Deadline 6 - Response to Submissions Received by Deadline 5

1) Formal change request relating to the Isleham plane crash site, outlined in REP3A-037 and Sunnica's Second Change Application REP5-059

Drawing Title  
**FIGURE 10-14C  
 LANDSCAPE MASTERPLAN  
 SUNNICA EAST SITE B**

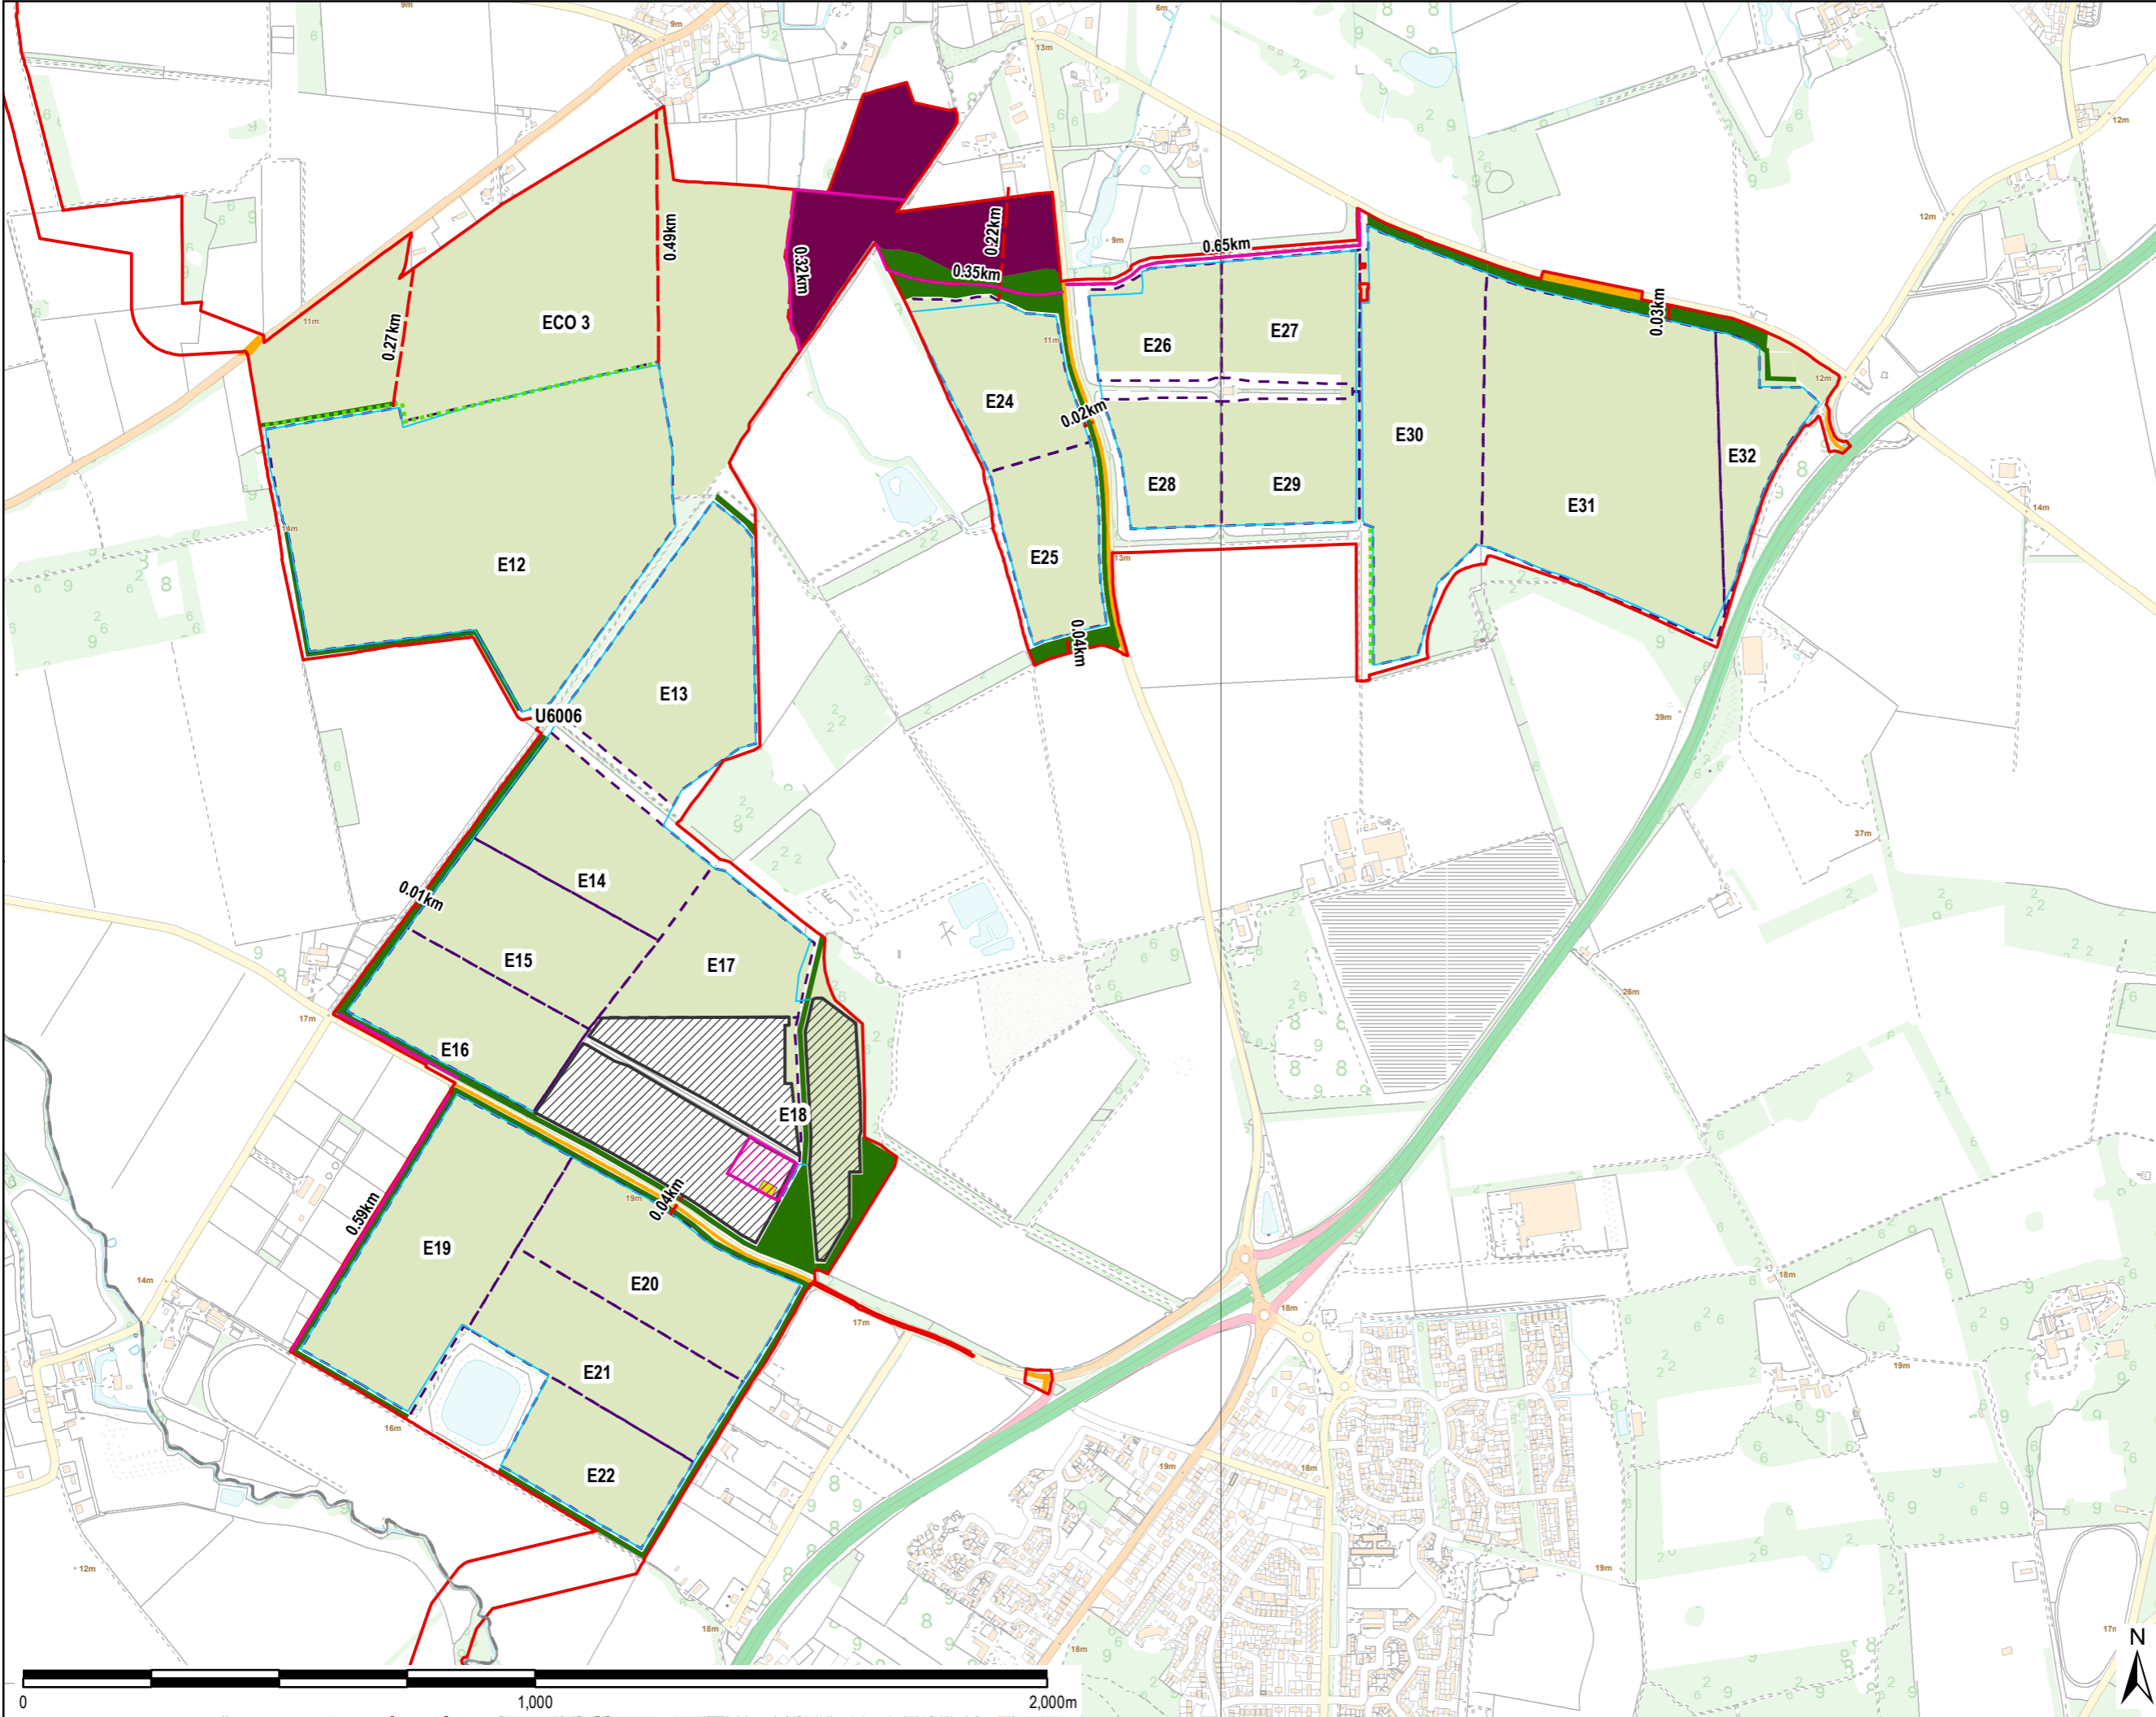
- 1.3 A 'bare minimum' approach appears to have been adopted, with Sunnica selecting the smallest possible exclusion zone over the main impact crater (a mere 50m square) and, despite requests by the Cambridgeshire councils (REP4-080) to not engulf the site, Sunnica have proposed to do exactly that.

- 1.4 The small 50 m crater exclusion zone would be engulfed by solar panels; these would in turn be engulfed by woodland planting and hedgerows so as to render the crater hidden from all.

- 1.10 The engulfing of the site by panels and then by trees would completely block the views over the site from the village. The important visual connection would be lost. The passing thoughts and memories would, over time, no longer be triggered. The current peaceful, agricultural setting would be drill piled into, damaging and interfering with any remains. The majority of the crash area would then be covered over in industrial equipment, fenced in and then finally surrounded and further hidden by trees and hedgerows. This is the opposite of how the site has remained today (Figure 1).

1.16 Even the wider exclusion area of 100m would still fail to preserve the visual connection from the village with the site if the mitigation tree/ hedgerow planting went ahead, and if it were surrounded by panels/inverters etc.
